DRB CASE ACTION LOG

4	on No.: 07DRB-70135 (P&F)	Project # 1004941
		: TRAMHILL TOWNHOMES Group NM Inc.	Phone No.: 275-7500
Your re	equest for		AL PLATS), (MASTER DEVELOP. PLAN), was ation of signature(s) to the following departments.
	TRAN	SPORTATION:	
	UTILIT	TES:	
	CITY	ENGINEER / AMAFCA:	
	PARK:	S / CIP:	
X -	PLANI	NING (Last to sign): 4615 recova	dxf
		-Tax printout from the County Asses	for the County Clerk. asurer. he County Clerk). RECORDED DATE: ssor.
		with the County Clerk. Property Management's signature signature. AGIS DXF File approval required.	t be obtained prior to the recording of the plat must be obtained prior to Planning Department's
		Copy of recorded plat for Planning].

CITY OF ALBUQUERQUE PLANNING DEPARTMENT July 25, 2007 **DRB Comments**

RE: Tract A-1, Tramhill Townhomes/p&f

PLAT OF
TRACT 1, COPPER RIDGE APARTMENTS
AND
TRACT A-1-A, TRAMHILL TOWNHOMES
BEING A REPLAT OF TRACTS B & C, FOOTHILL ESTATES
AND TRACT A-1, TRAMHILL TOWNHOMES

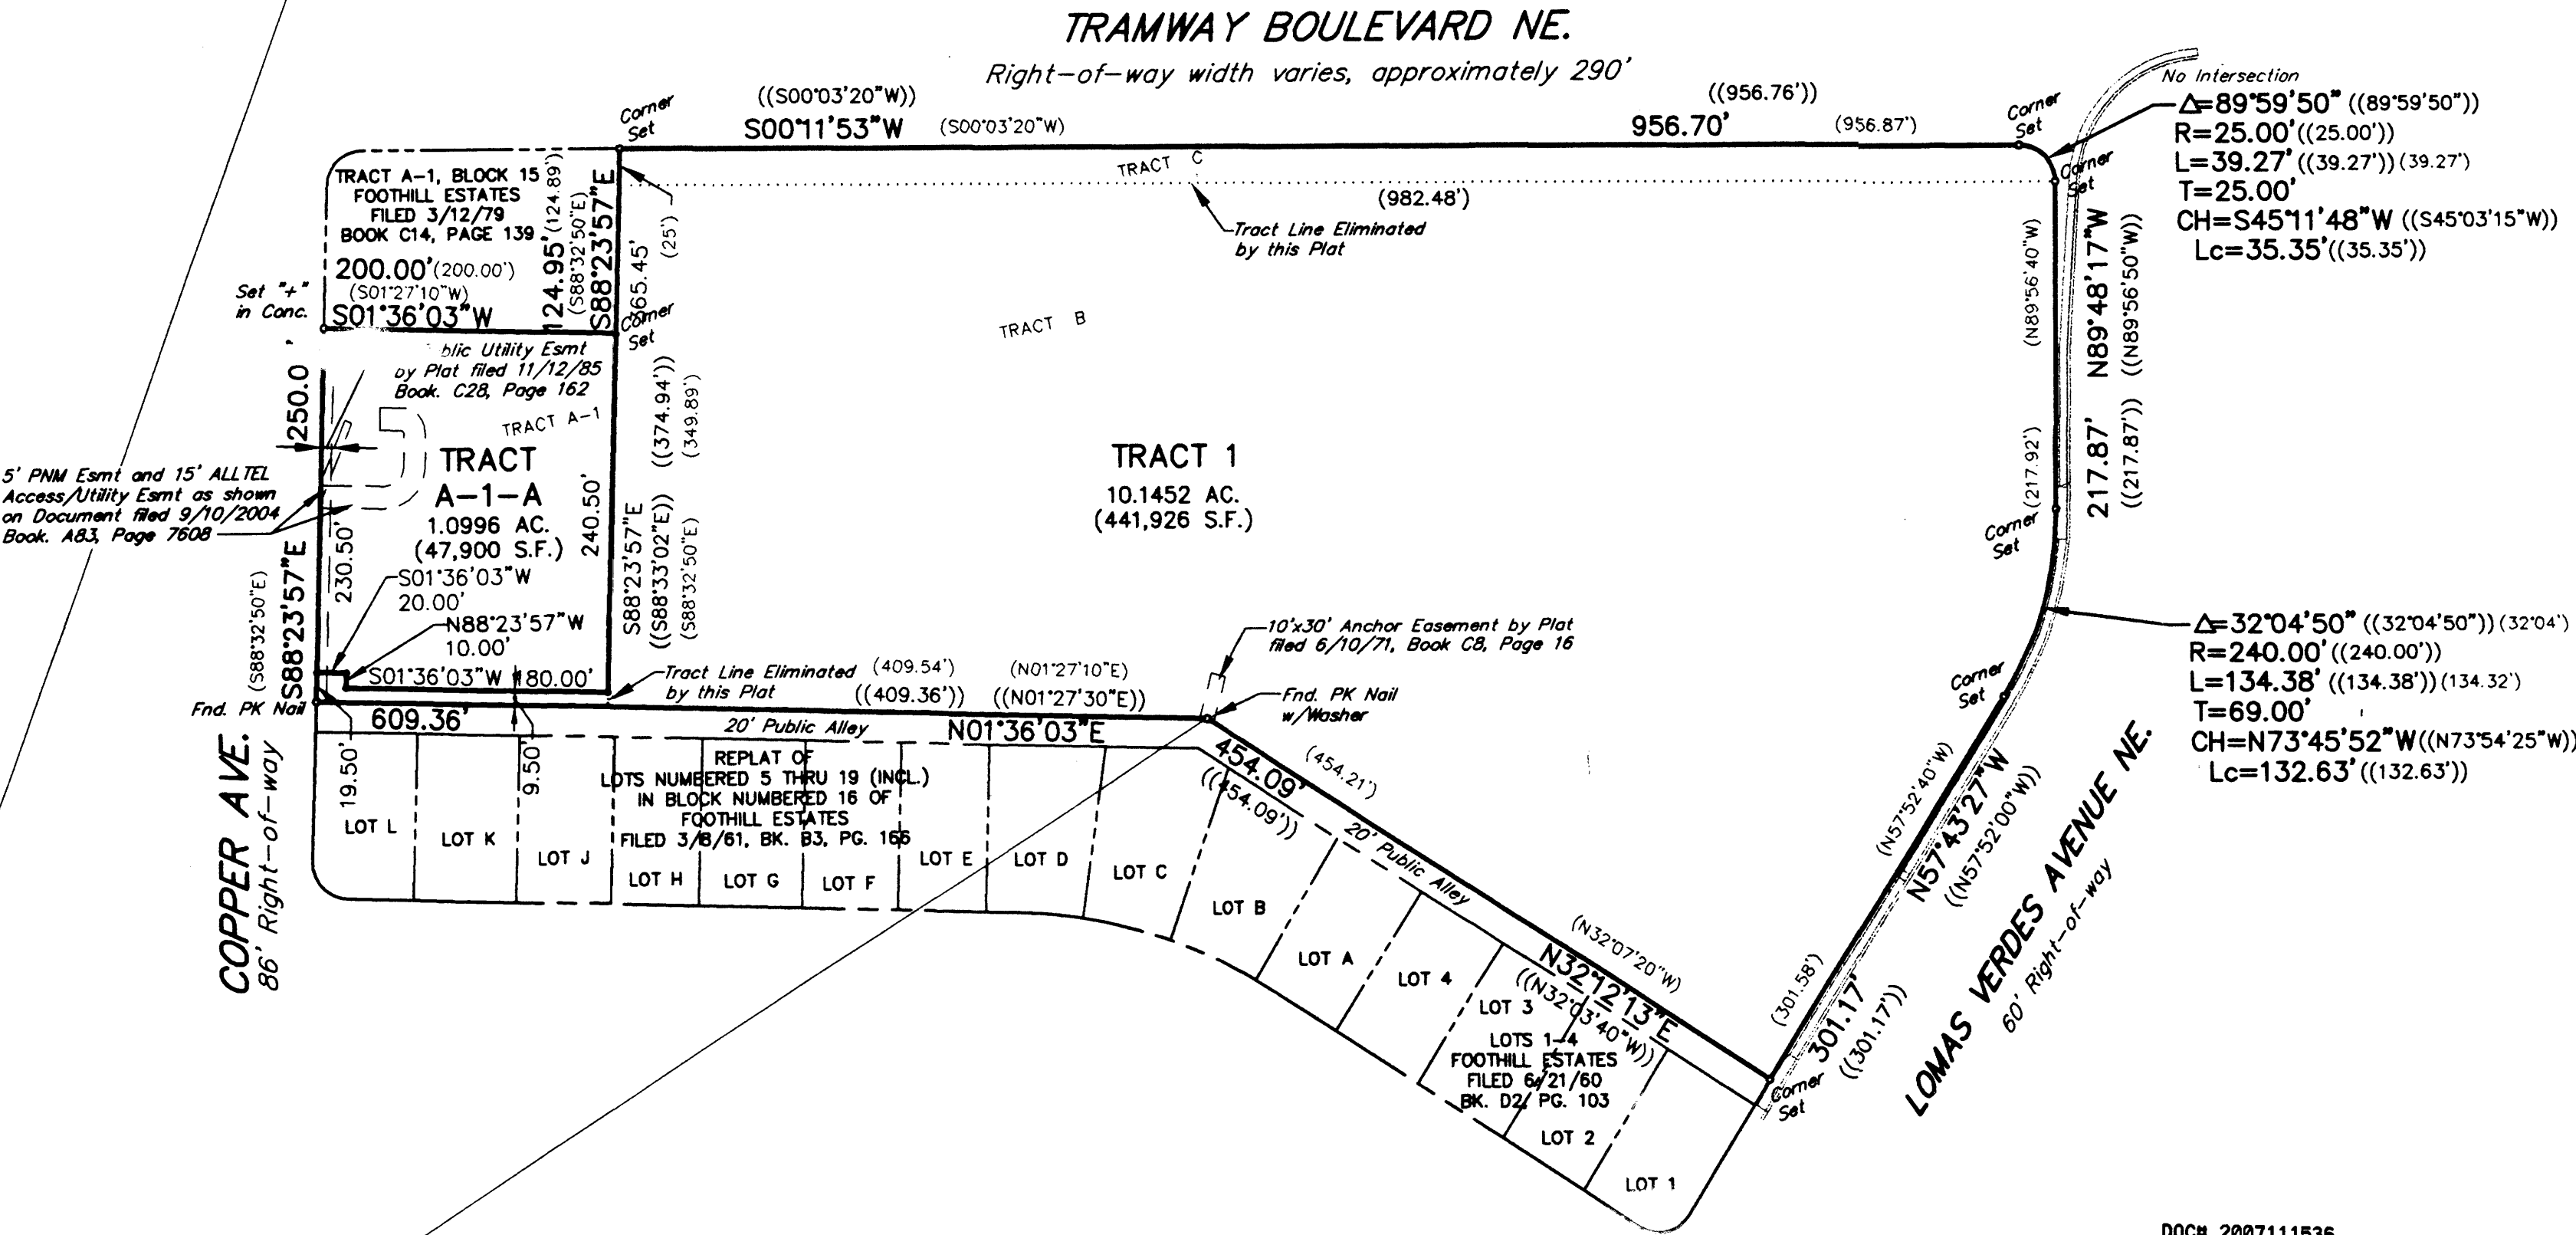
DEVELOPMENT REVIEW BOARD – SPEED MEMO			
	DRB CASE NO/PROJECT NO: 100	4941 <u>AGE</u>	NDA ITEM N	O: 13
	SUBJECT:			
	Final Plat Preliminary Plat			
	ACTION REQUESTED:			
	REV/CMT: () APPROVAL: (X) SI	IGN-OFF: ()	EXTN: ()	AMEND: ()
	ENGINEERING COMMENTS:			
P.O. Box 1293	A cross lot drainage easement is required.			
Albuquerque				
New Mexico 87103				
www.cabq.gov				
	RESOLUTION:			
	APPROVED; DENIED; DEFERRED	_; COMMENTS PRO	VIDED; WITE	IDRAWN
	DELEGATED: (SEC-PLN) (SP-SUB) (SP-BI	P) (FP) TO: (UD) (CE) (TRANS) (PRKS) (PLNG)
	SIGNED: Bradley L. Bingham		DATE: JULY 2	5. 2007
